Botley West Solar Farm – EN010147

Representation concerning the Applicant's latest submissions

From Interested Party: Steven Jenkins

**Landscape, Ecology and Amenities Layer Plan**  
 Central Site Area 2 of 4

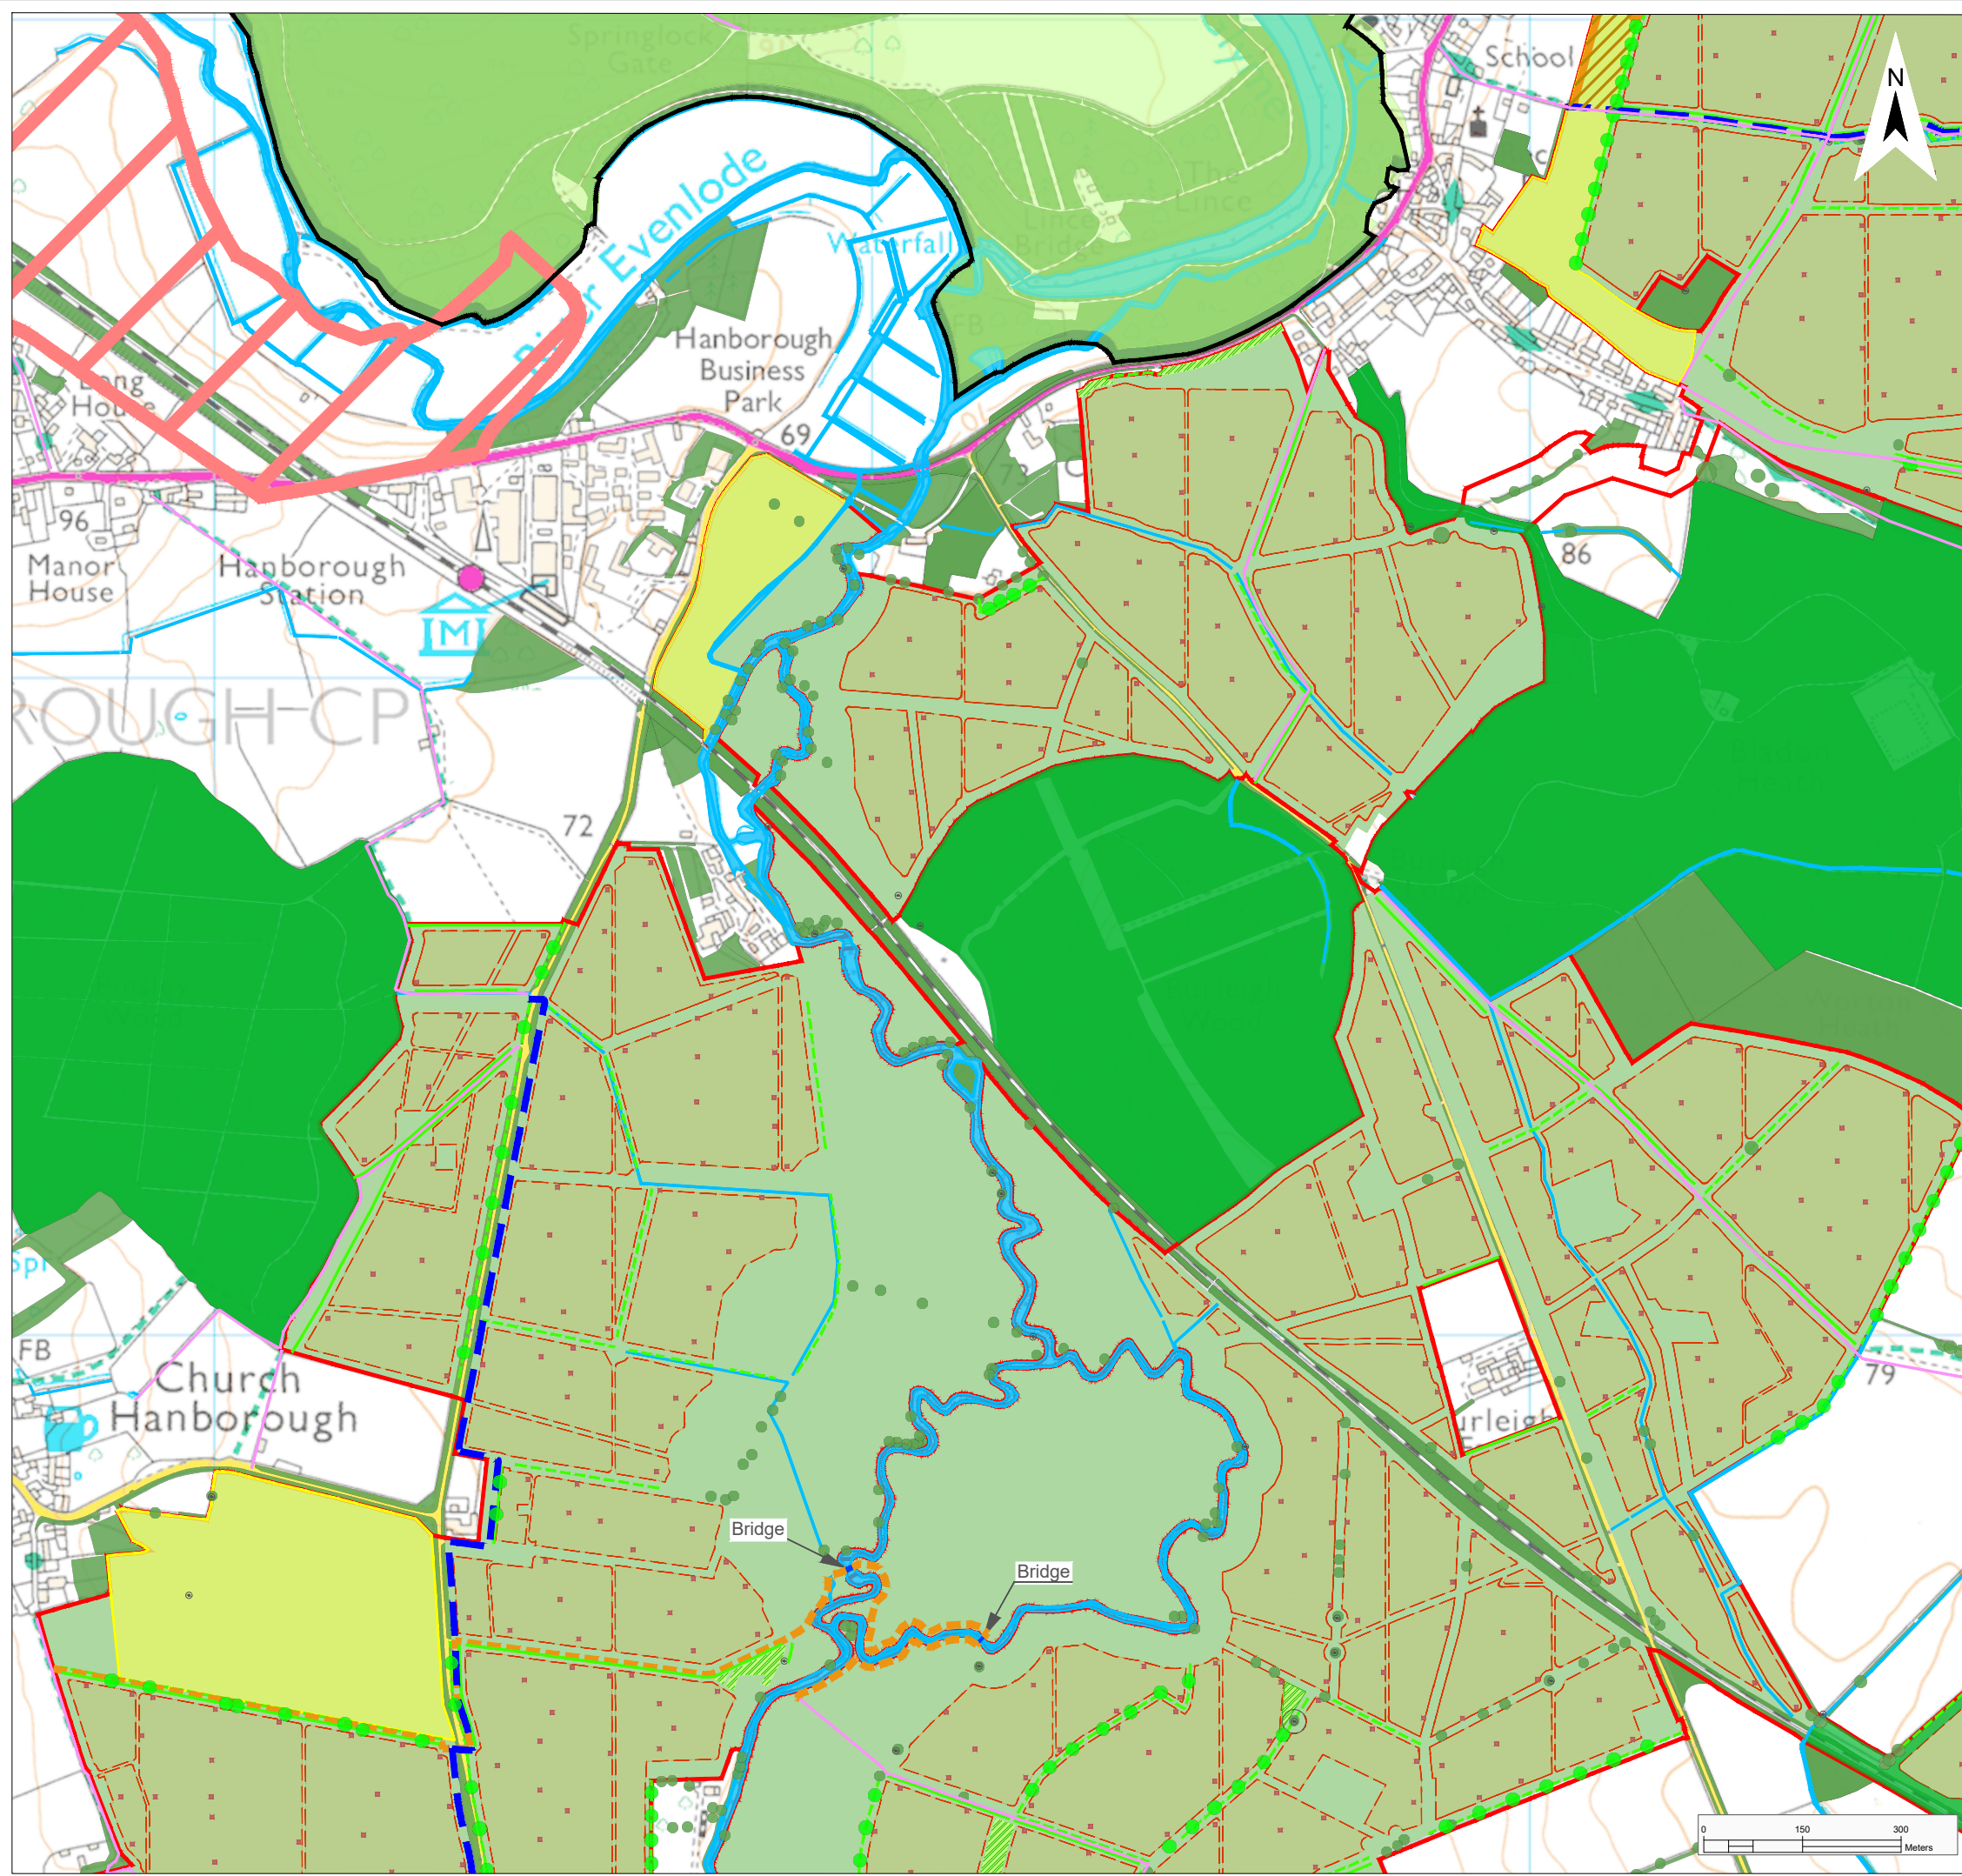
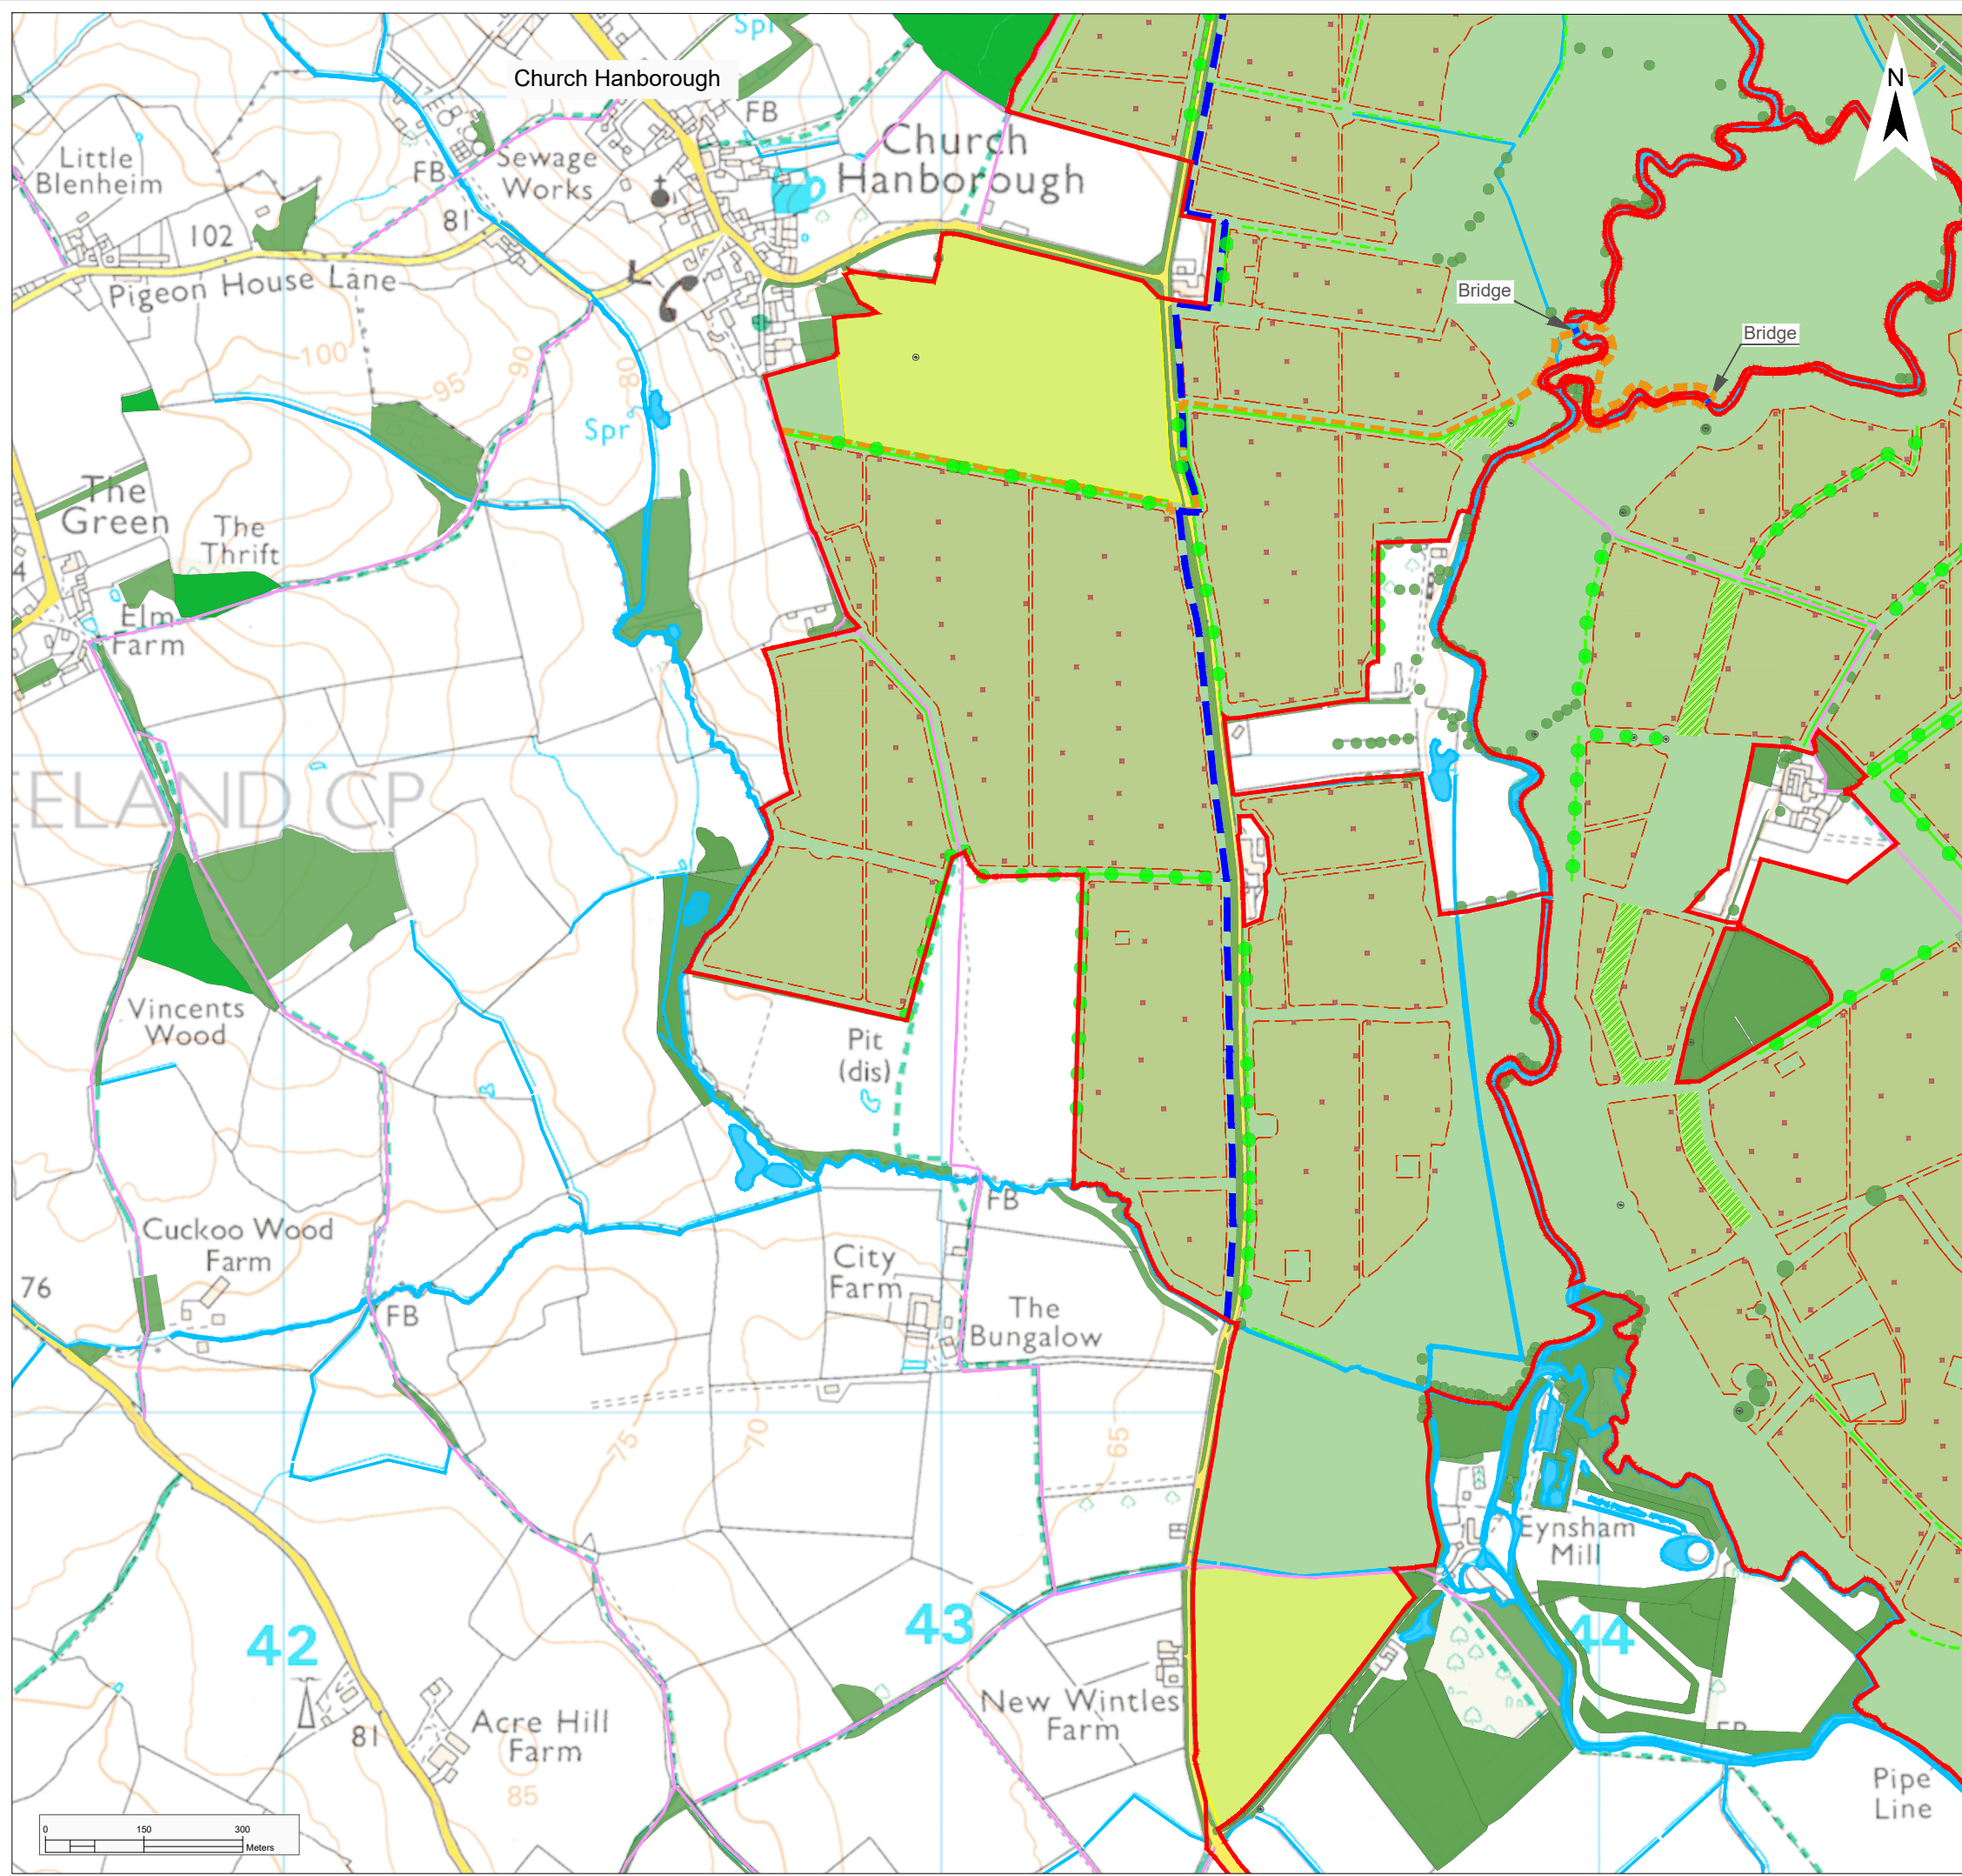
The proposed cycle path along Lower Road continues to appear on the latest Masterplan, despite a verbal agreement during the Examiners' Site Inspection on **7 October 2025** that it would be removed from the application. The continued inclusion of this feature raises concerns about the accuracy and reliability of the latest Masterplan.

The submitted plans should accurately represent what is actually proposed and agreed. They should not contain infrastructure that the Applicant has previously indicated would be removed.
